Application No: Y/29/21/HH
Site Address: Magnolias Church Lane Yapton BN18 0EH
Description of works: Erection of double garage.

Thank you for your internet representation made on 29th March 2021 which has been recorded as an objection with the comments as follows:

project			
MAGNOLIAS CHURCH LANE YAPTON ARUNDEL BN18 0EH			
drawing title			
PROPOSED GARAGE BLOCK PLAN			
date			
11/01/2021	scale	1:500 @ A1	
job no.	drg. no.	rev	
JA-MAG-02	01	A

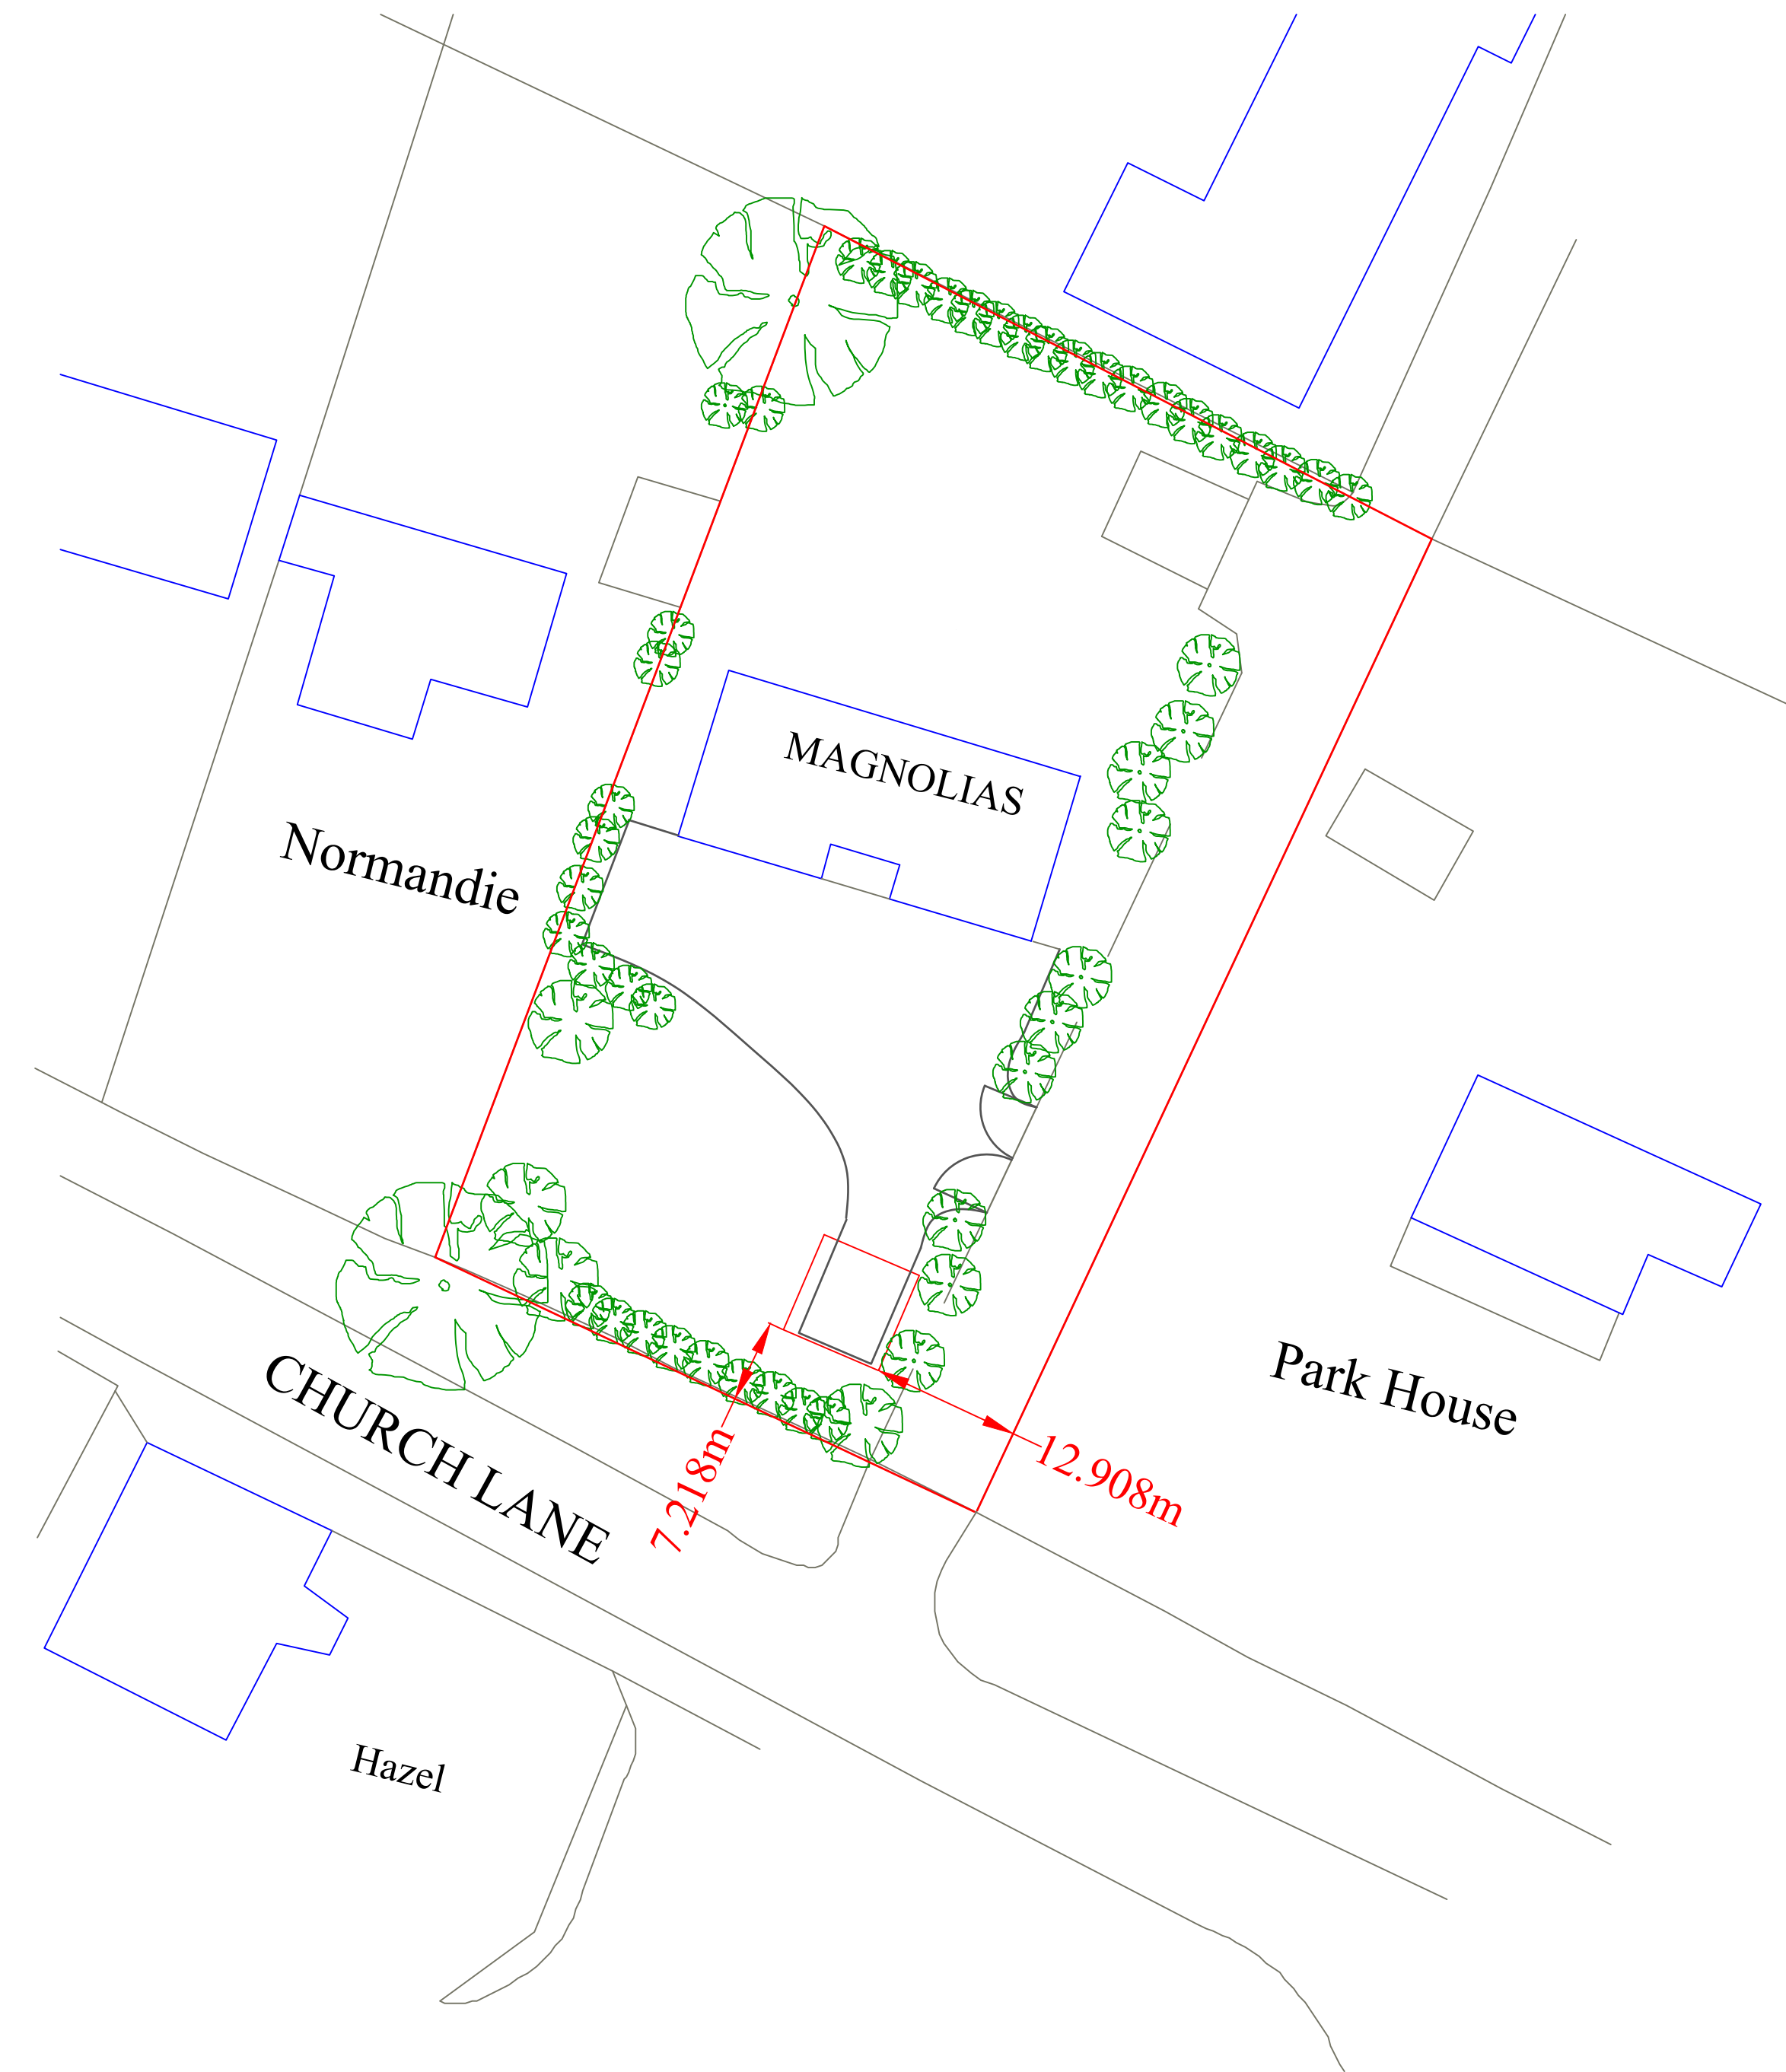
This proposal of a garage in the front garden of this property will be out of character to the rest of the north side of Church Lane. A satellite view of Church Lane shows that all the properties have a long frontage with no outbuildings. There is a covenant on the original building of the houses which states "No building shall be erected within forty feet of the road boundary nor within eight feet of the east and west boundaries." Although the properties were built at different times it is obvious that the building line has been respected along the north side of Church Lane. The Design and Access statement claims that the application site "is located within a row of modern detached dwellings located on the north side of the lane". I don't know what is regarded as 'modern' but the plots were started at least 60 years ago. Also the 'screening' of hedges and trees could easily be cut down in the future and the proposed building revealed.

AYLING-GROUNDWORKS.CO.UK			
project MAGNOLIAS CHURCH LANE YAPTON ARUNDEL BN18 0EH			
drawing title PROPOSED GARAGE ELEVATIONS			
Drawn by J. Ayling © COPYRIGHT			
date	11/01/2021	scale	1:50 @ A1
job no.	JA-MAG-02	drg. no.	03
		rev	A

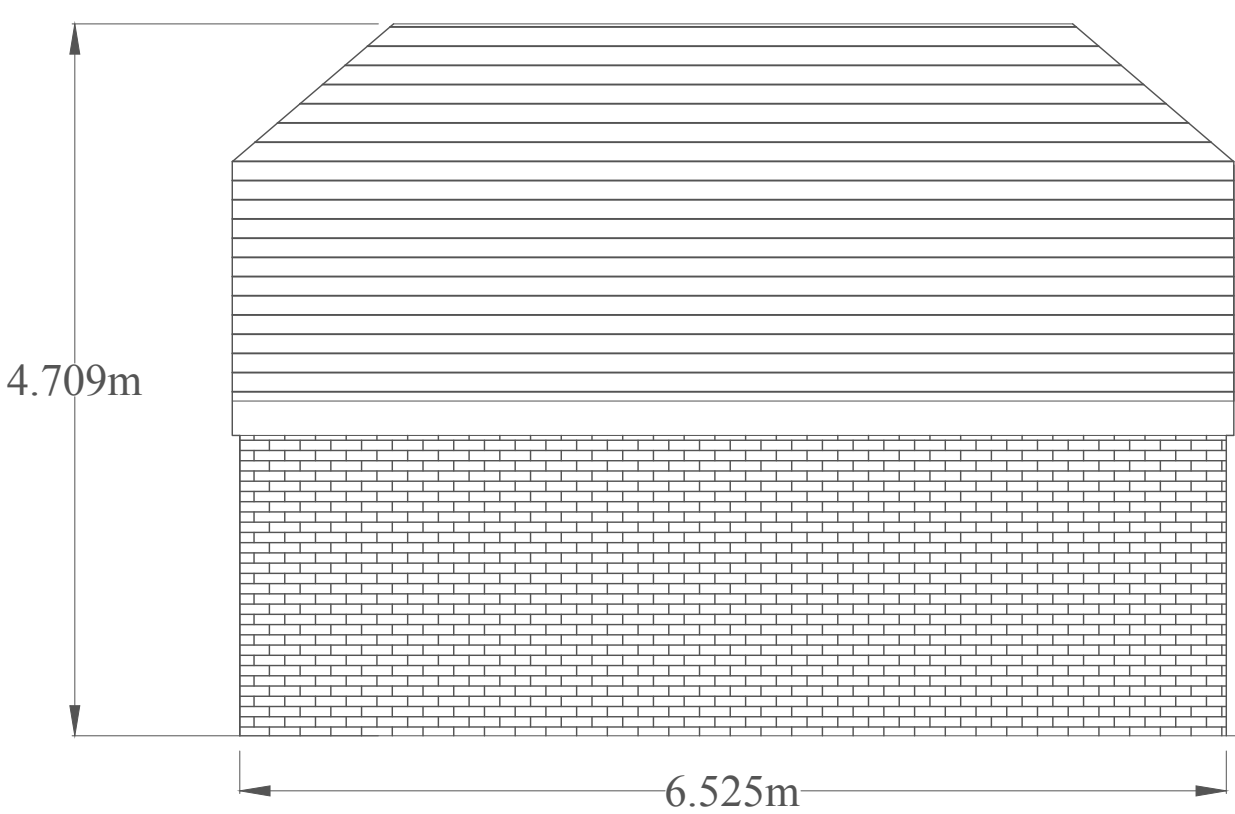
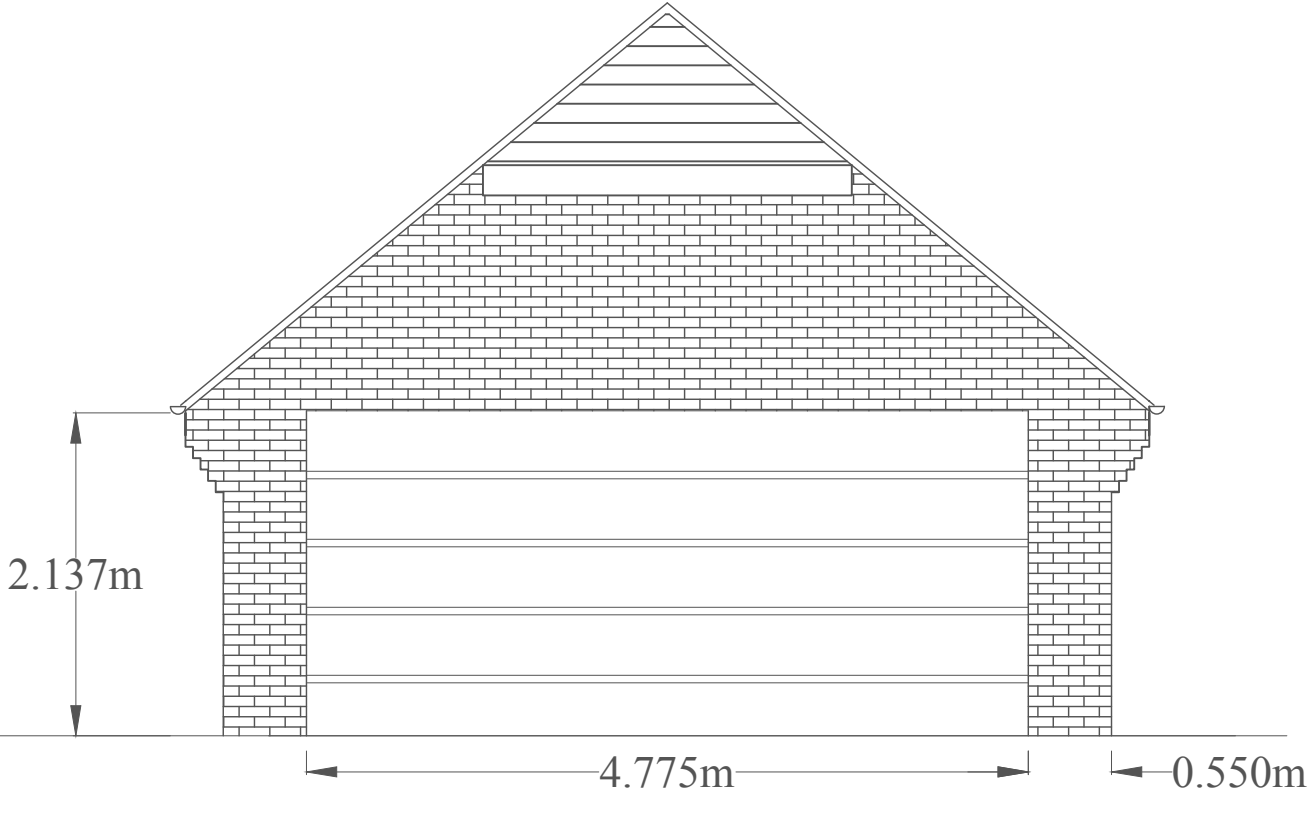
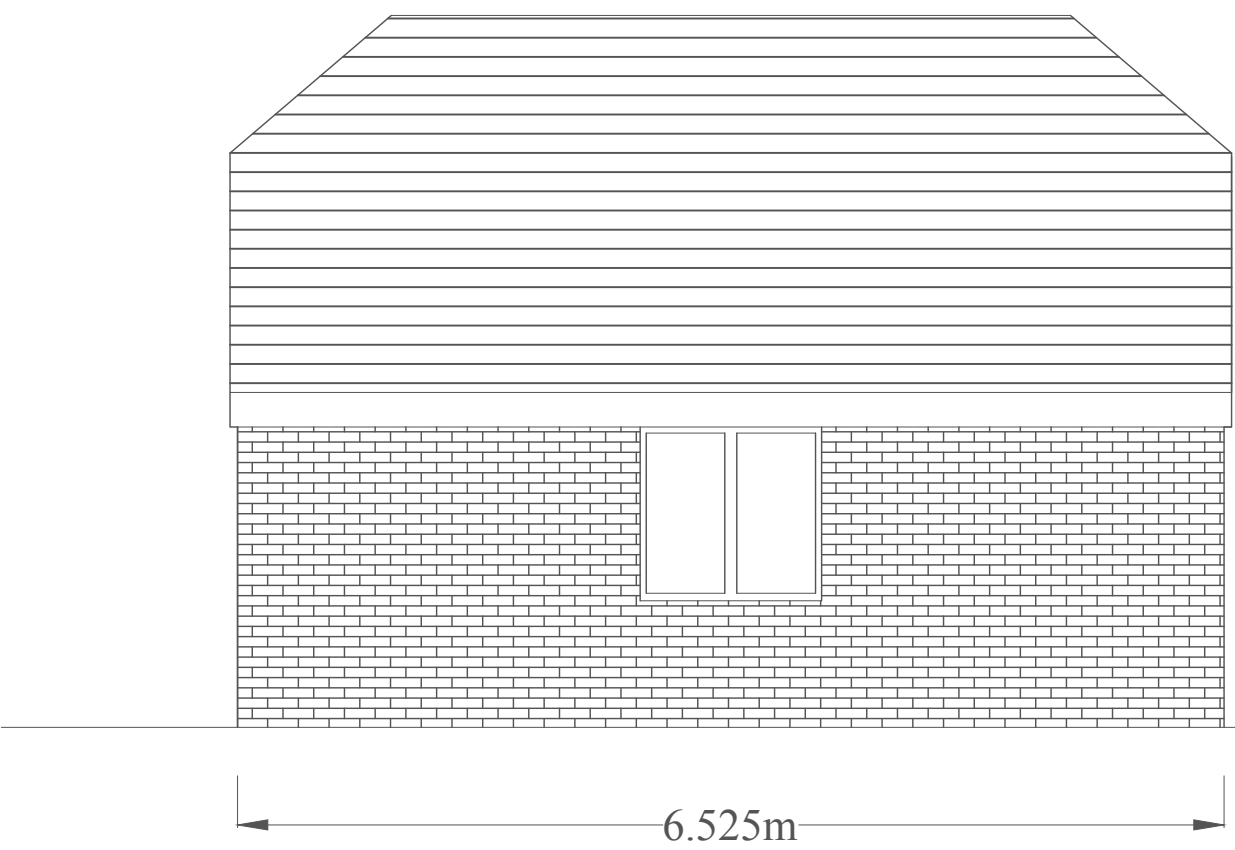
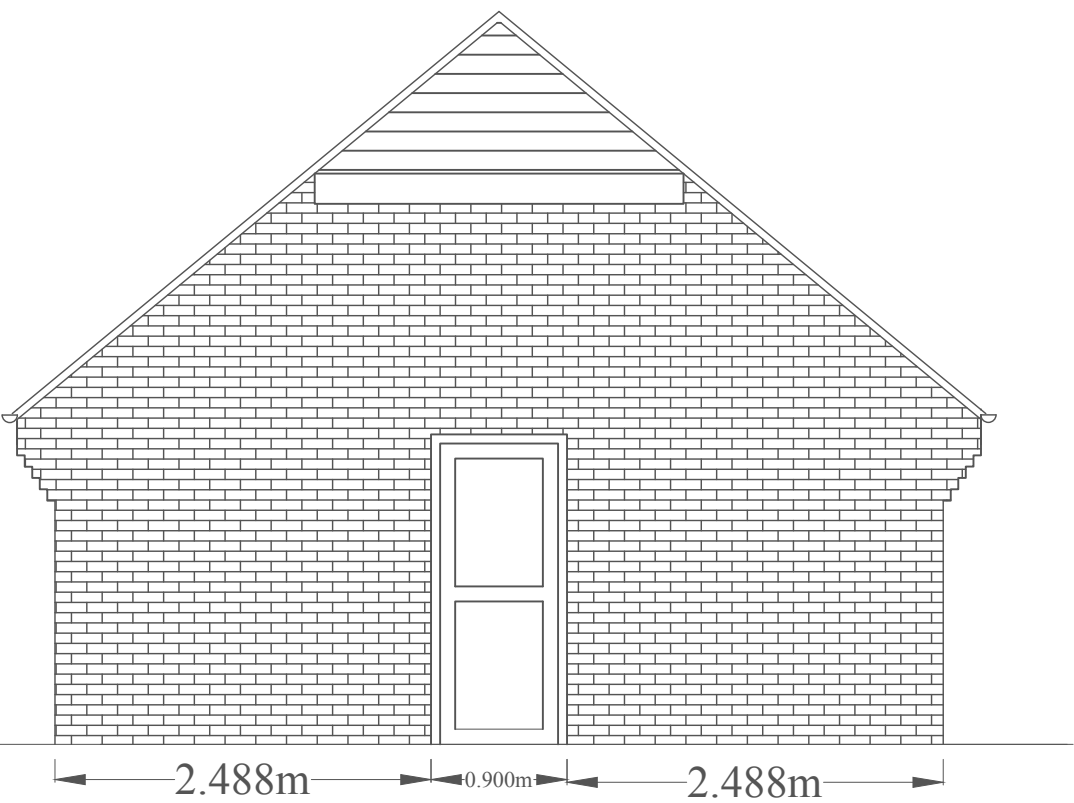
The proposed structure is described as 'modest in form, height and design' with a 'shallow pitched tiled roof' - but the elevation drawing shows a single storey building with a large pitched roof which doubles the height of the structure so that it looks like a house. Surely this is not necessary for a garage anyway. The size is also compounded by the fact that the site is on elevated ground and would therefore be more visible and imposing.
